TECHNICAL NOTE - D.7.47

DATE:	04 July 2023	CONFIDENTIALITY:	Public
SUBJECT:	Change Request 3 – Environment Technical Note		
PROJECT:	HyNet - DCO	AUTHOR:	Various
CHECKED:	MT	APPROVED:	CL

An Environmental Statement (ES) was submitted to the Planning Inspectorate (‘the Inspectorate’) in October 2022 as part of a Development Consent Order (DCO) application (EN070007) for the HyNet Carbon Dioxide Pipeline development (hereafter referred to as the ‘DCO Proposed Development’). A Consolidated ES was subsequently issued at Deadline 4, this incorporated proposed changes that had been accepted by the ExA as part of Change Request 1 [CR1-124] and Change Request 2 [CR2-017]. The consolidated ES (hereafter referred to as the ‘ES’) sets out the findings of the full Environmental Impact Assessment (EIA) that was carried out for the DCO Proposed Development.

DRAWING TITLE  
**Ince - Above Ground Installation (AGI) Drainage Layout**

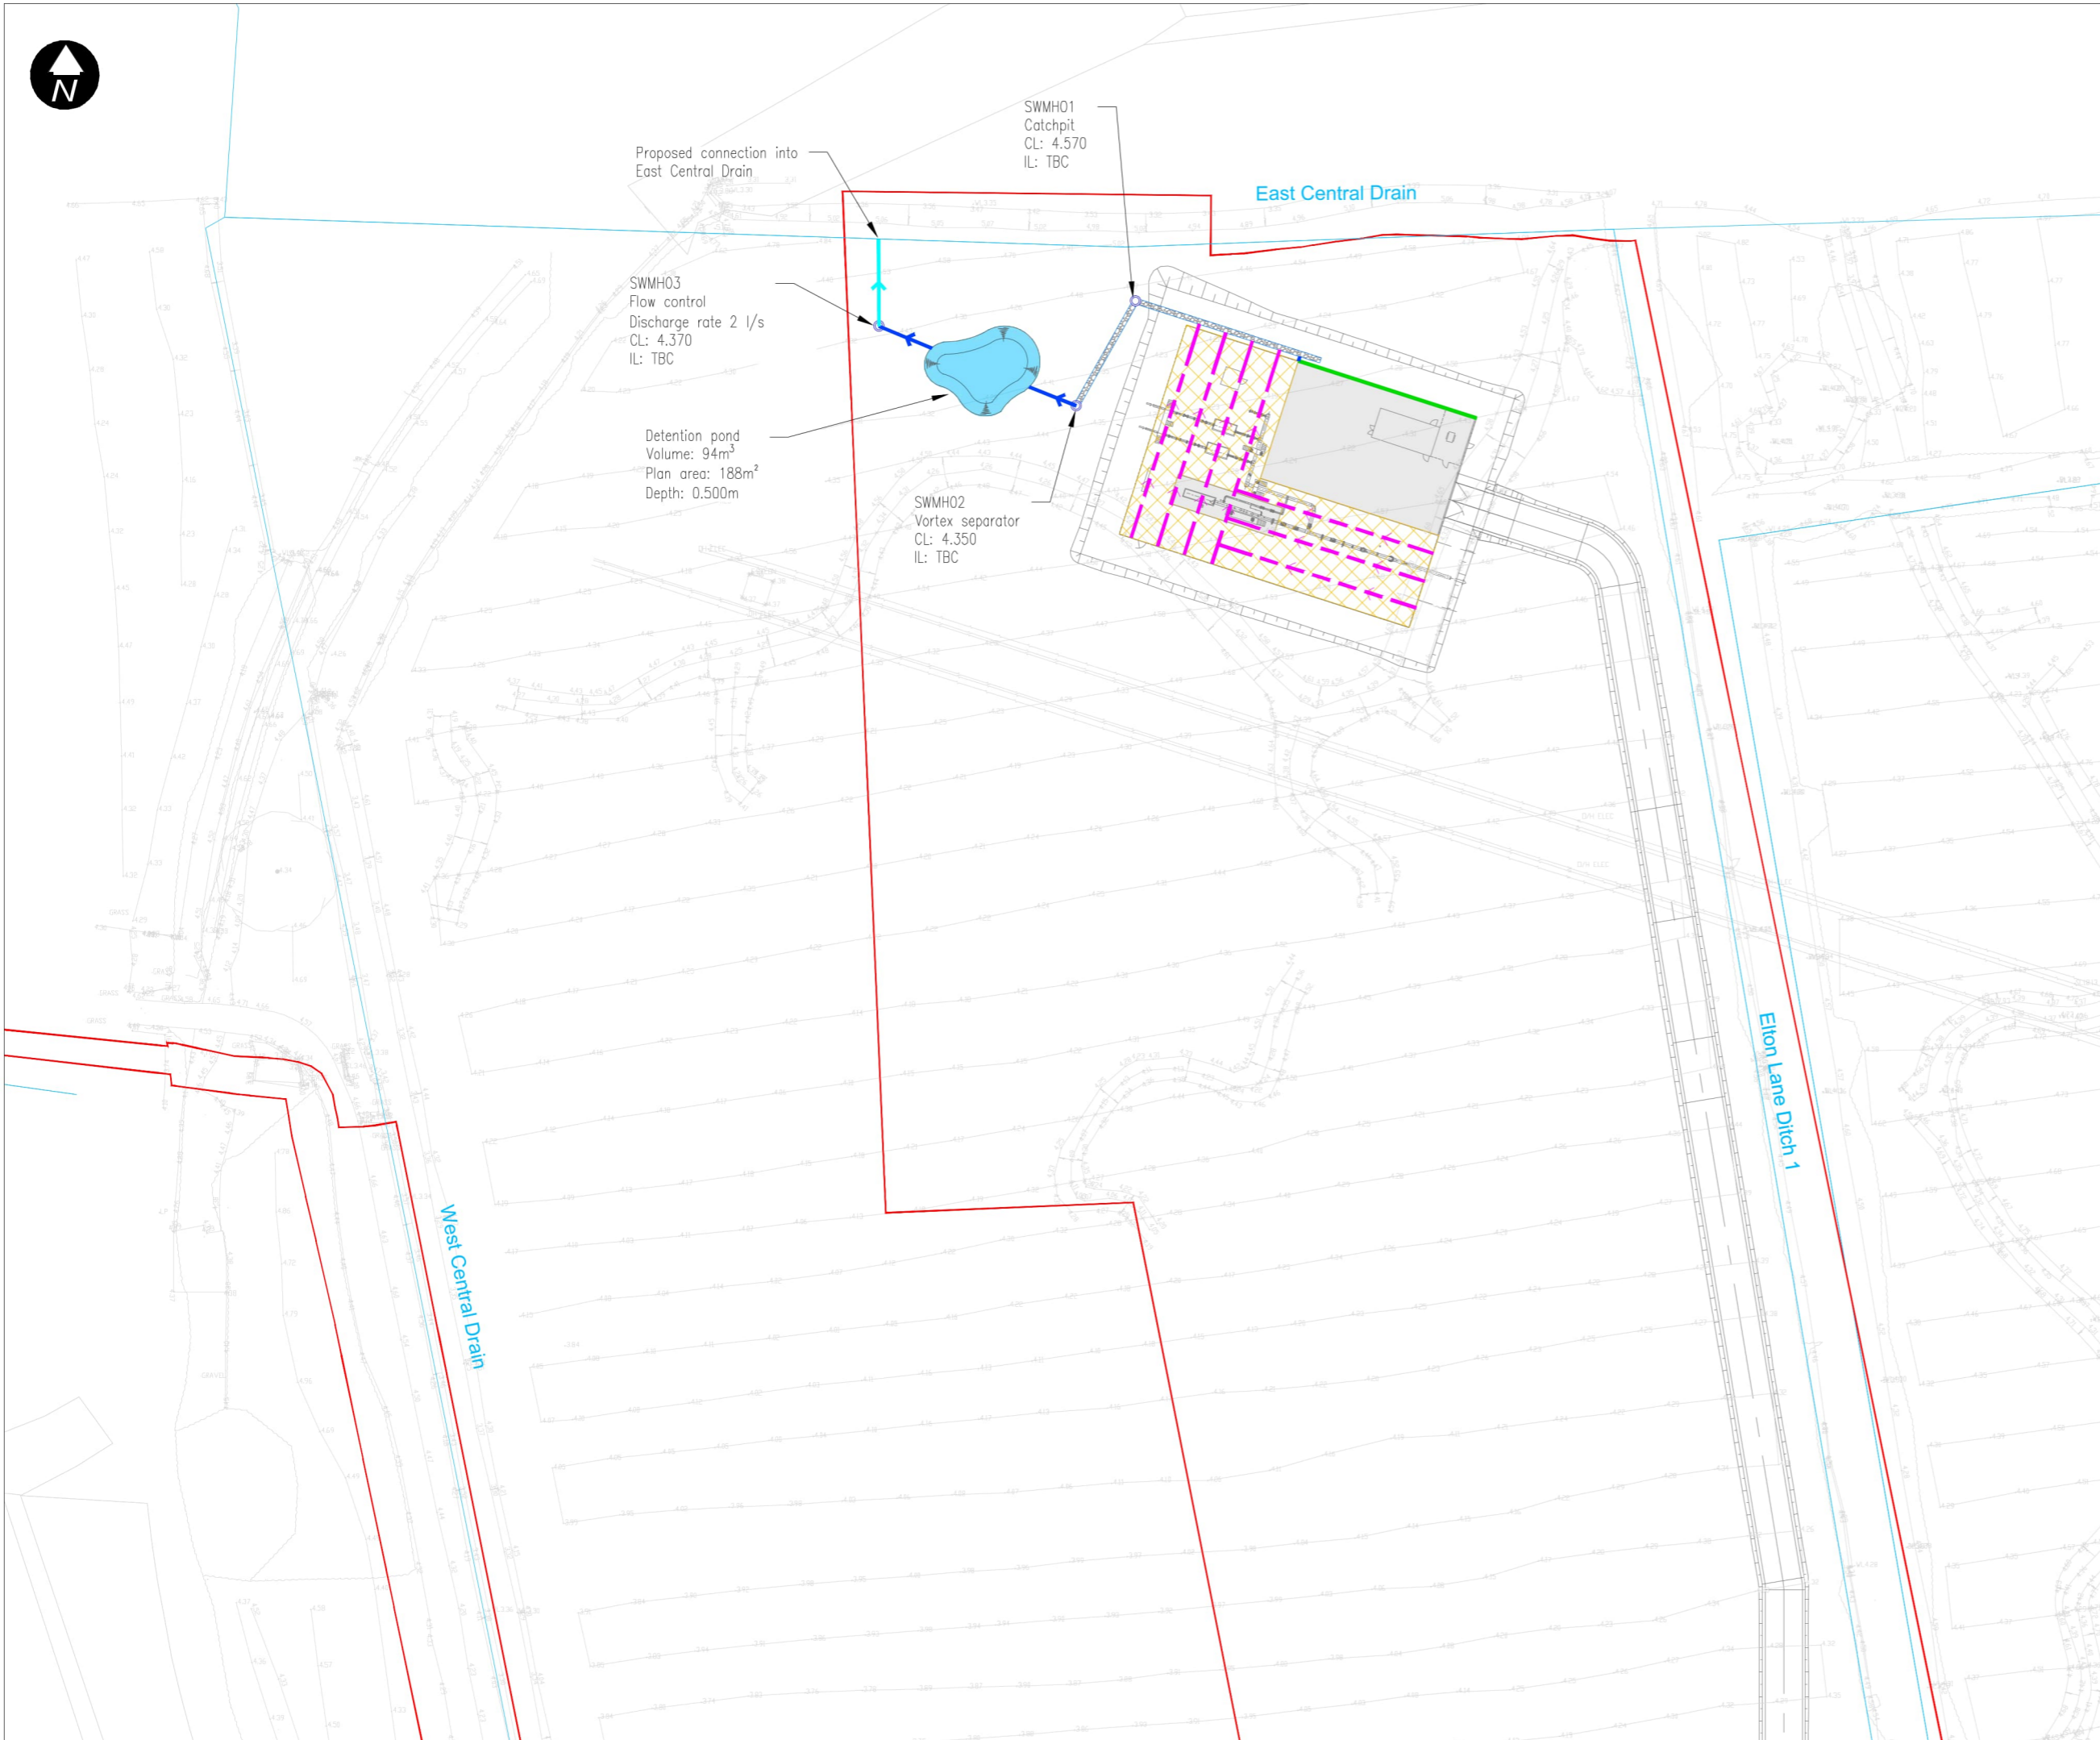
The Applicant proposes the removal of Plot 1-07 (**Figure A3 in Annex A**) and updates to the Outline Surface Water Drainage Strategy (**Figure A4 in Annex A**), due to the request from the interested landowners to avoid the outfall for the Ince AGI drainage pond connecting into the East Central Drain.

Paragraph 3.4.12 of Chapter 3 [REP4-029] will be changed to state *'The OSWDS (Document Ref: D.6.5.13) assumes for Ince AGI that discharge would be to Elton Lane Ditch 1 via an infiltration trench on the gravelled areas, vegetated attenuation pond and filter channel.'*

EN070007-APP-ES-6.1- Sheet 6

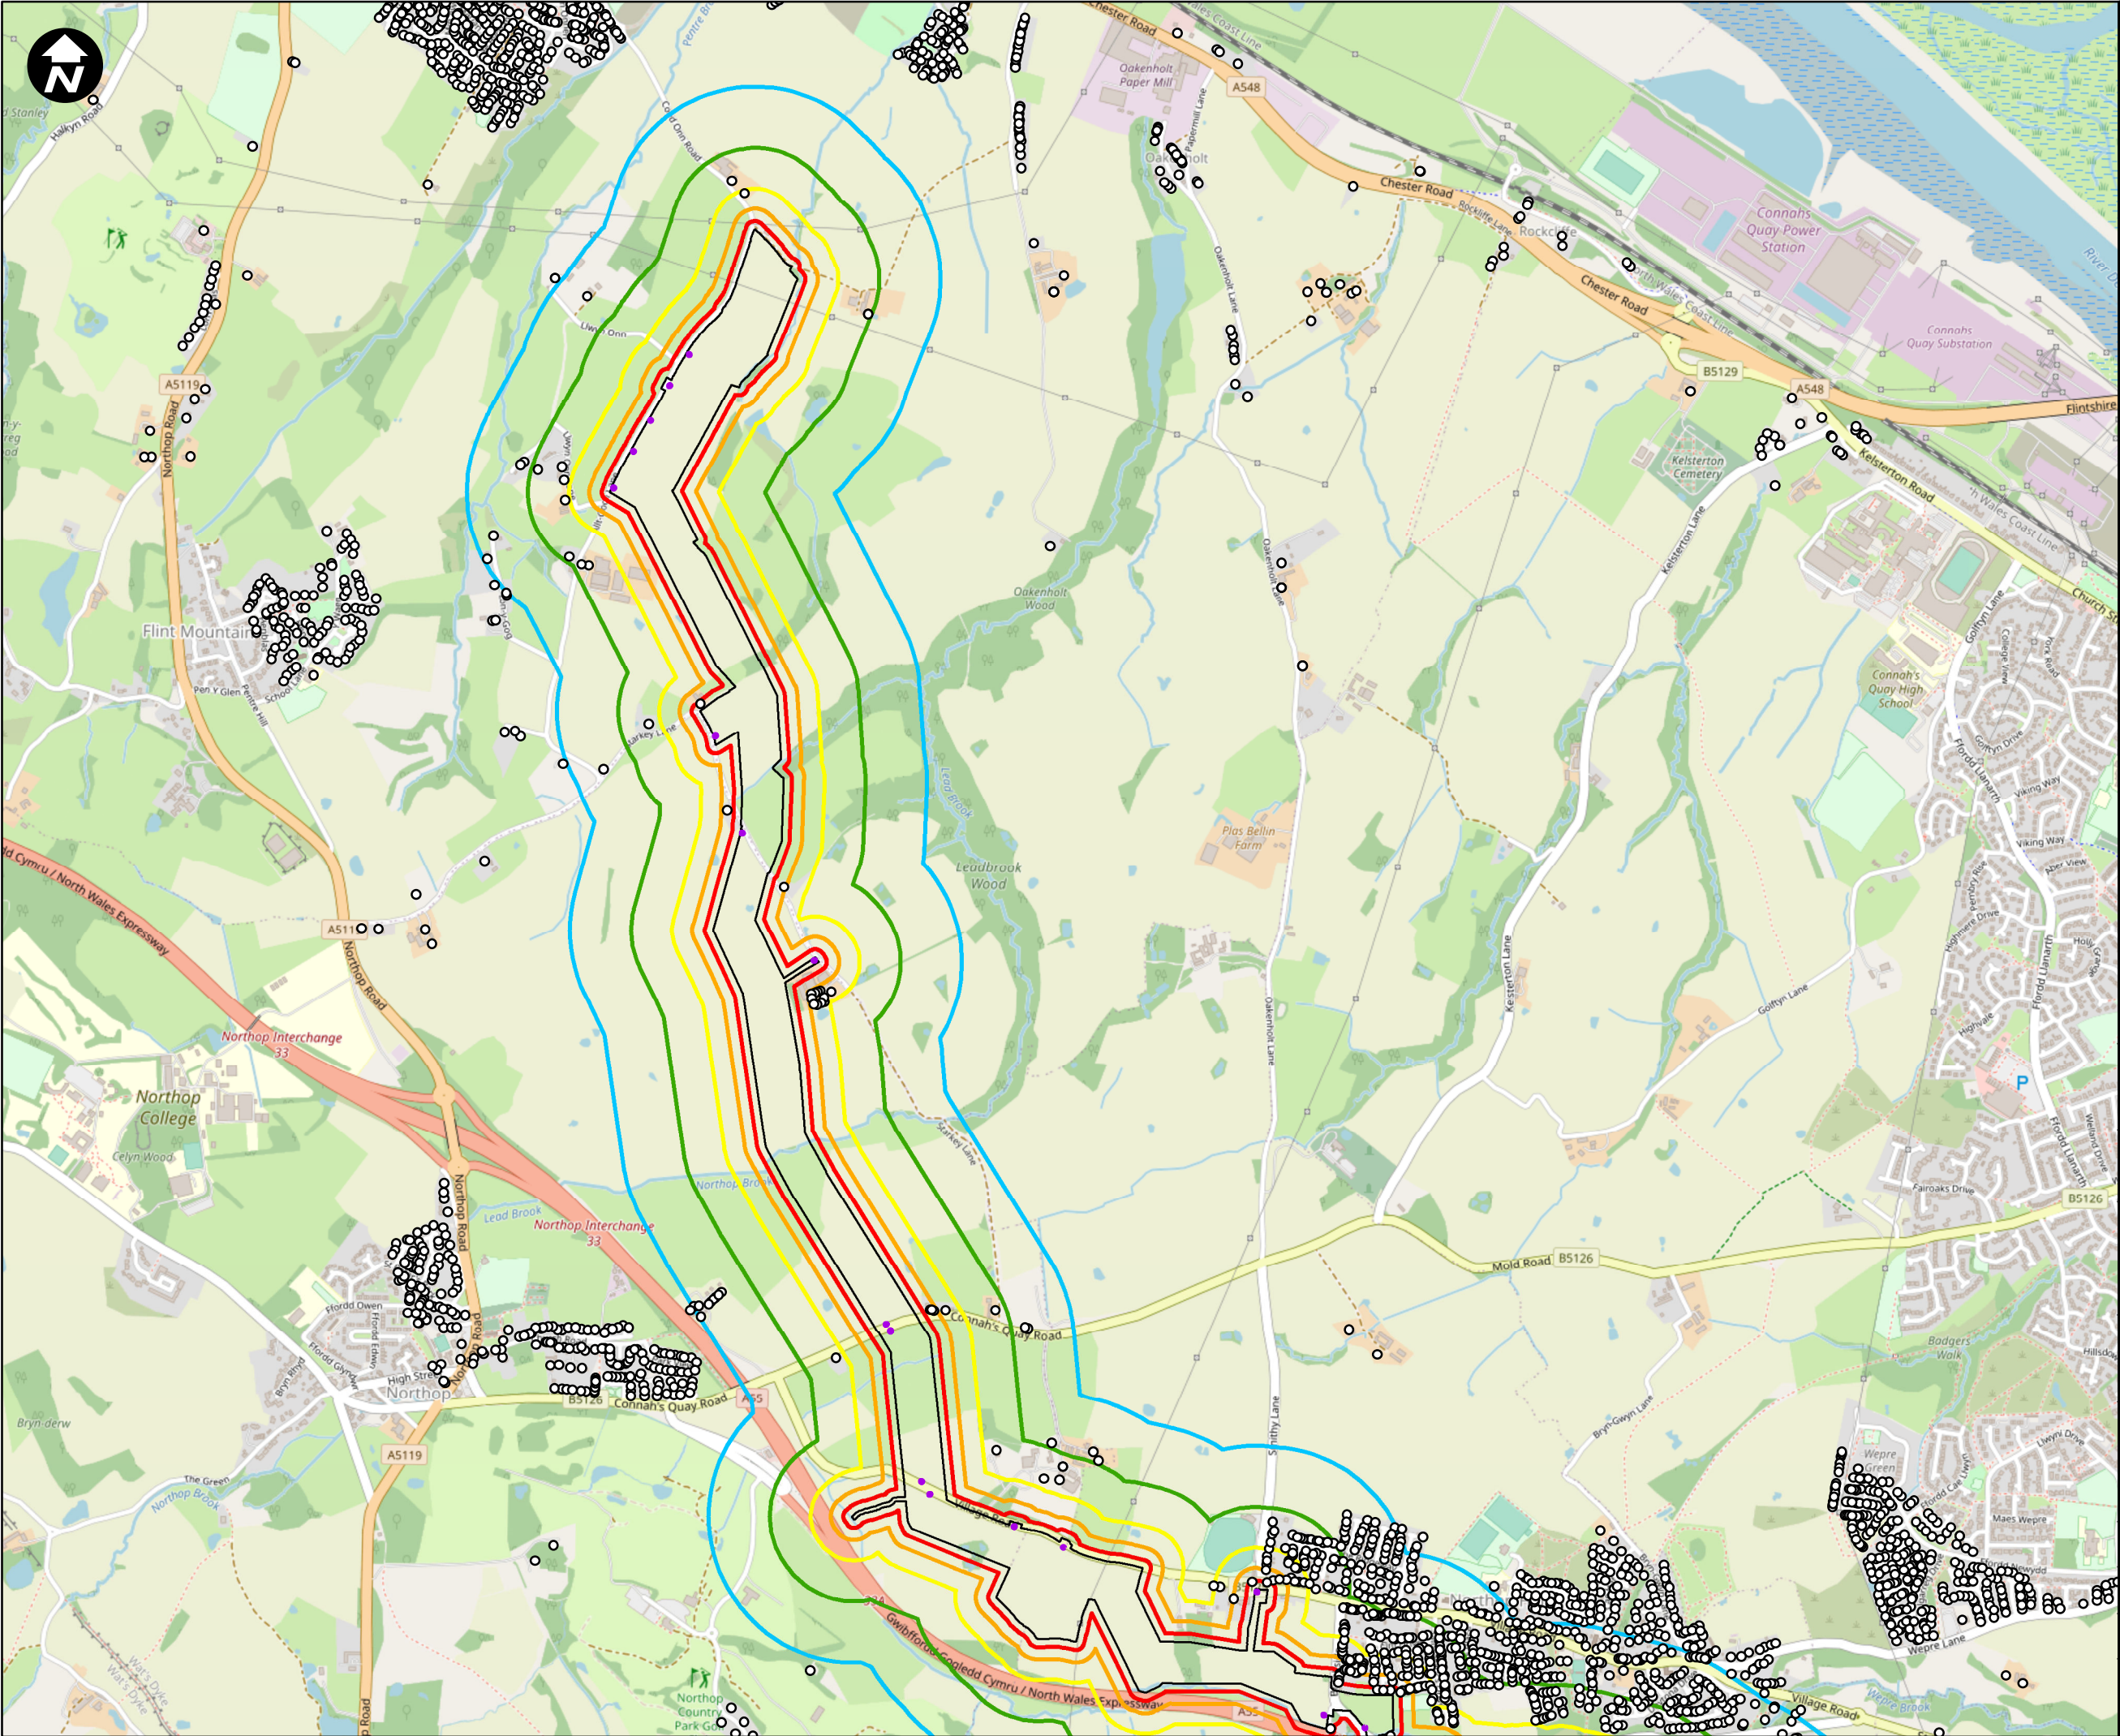
Sheet 6 of Figure 6.1 [REP4-210] will be updated to reduce the Newbuild Infrastructure Boundary and subsequent buffers as a result of removing Shotton Lane Centralised Compound.
